Application No: Y/13/21/HH
Site Address: Old Barn House Hoe Lane Flansham PO22 8NT
Description of works: Conversion of an existing detached carport with room above into an additional self contained dwelling ancillary to the main dwelling, removal of front window to main house & installation of bifolding doors.

Thank you for your internet representation made on 10th April 2021 which has been recorded as an objection with the comments as follows:

Drawing No. 01011 Drawing Name: Proposed Floor Plans

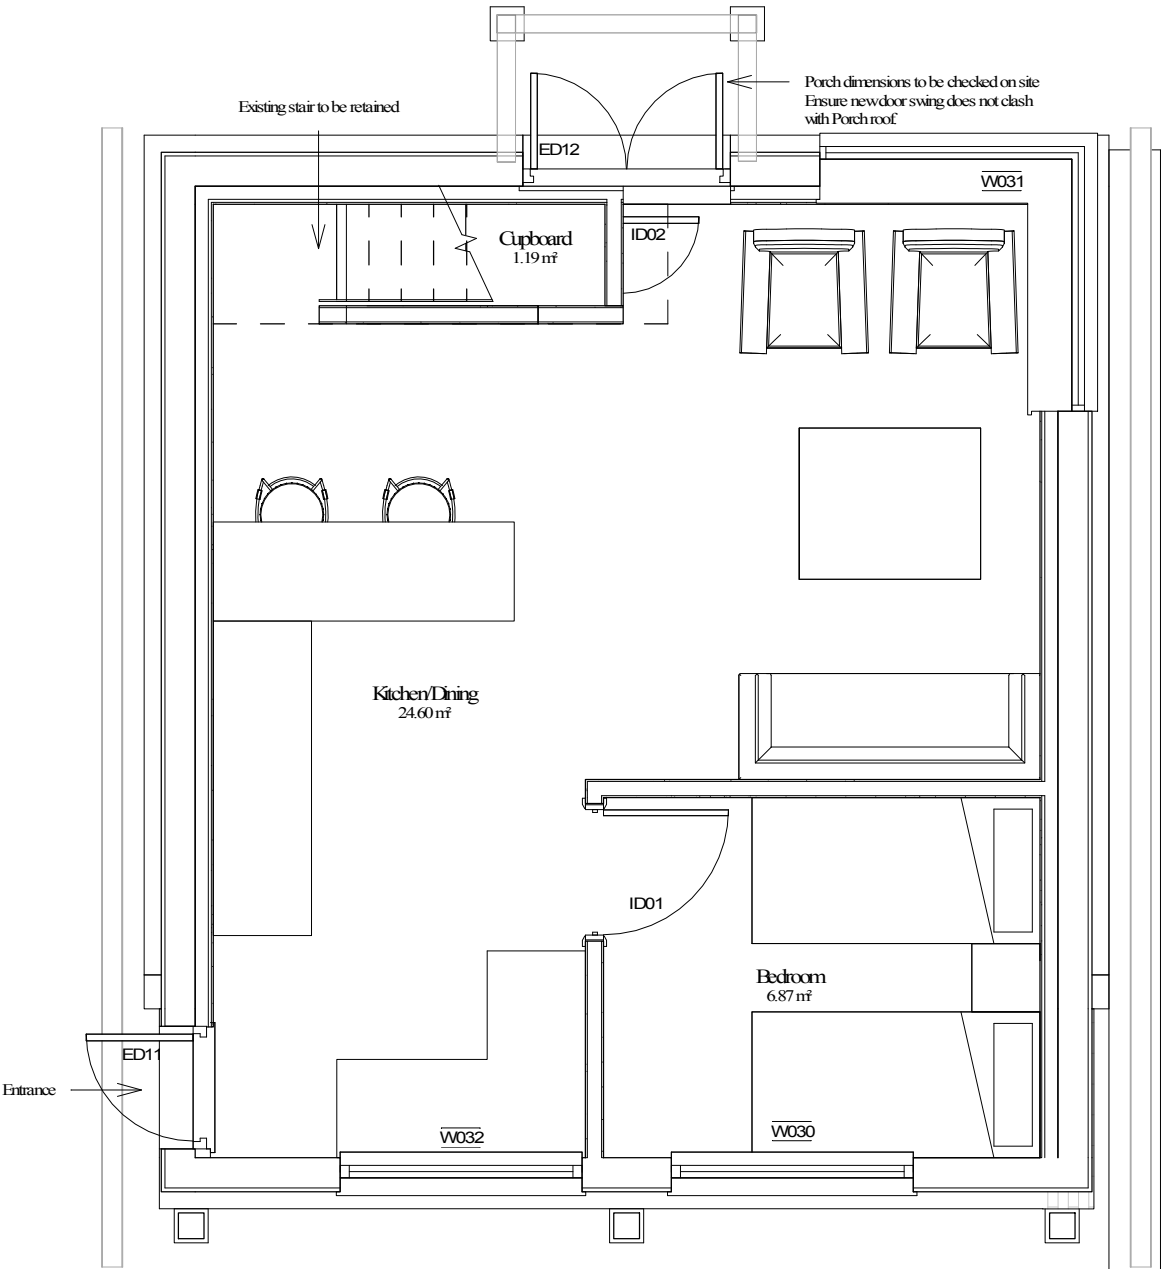
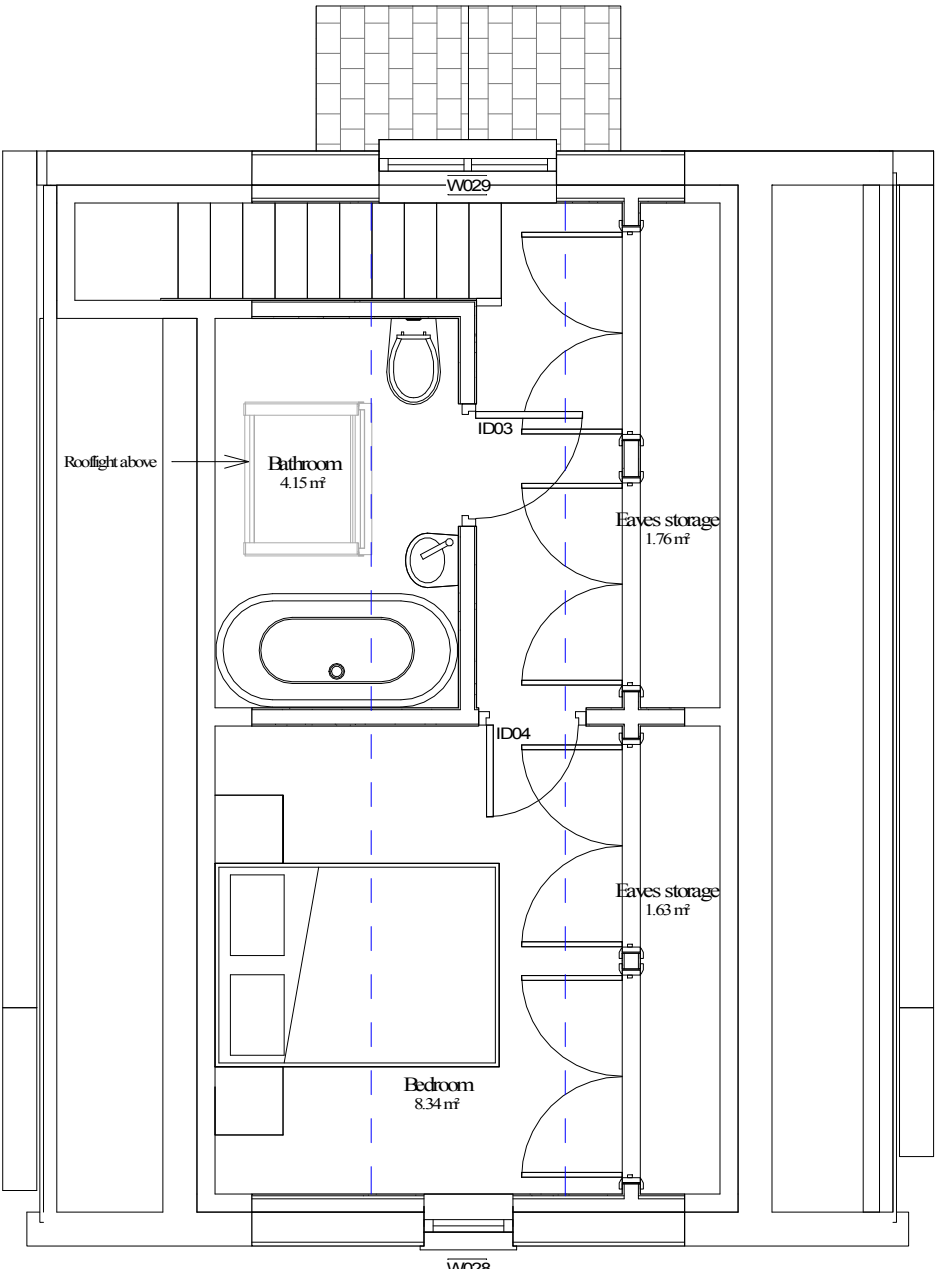
As I understand it, the proposed carport conversion will increase the site from 9 bedroom to 11 bedroom. This would seem overdevelopment on this centre-of-hamlet site, and implies a change of use from domestic to business. Of greatest concern is the parking provision, which would need to be greatly increased from the present provision, less the carport for proposed conversion, to provide off road parking for at least 11 cars. - 1 space per bedroom.
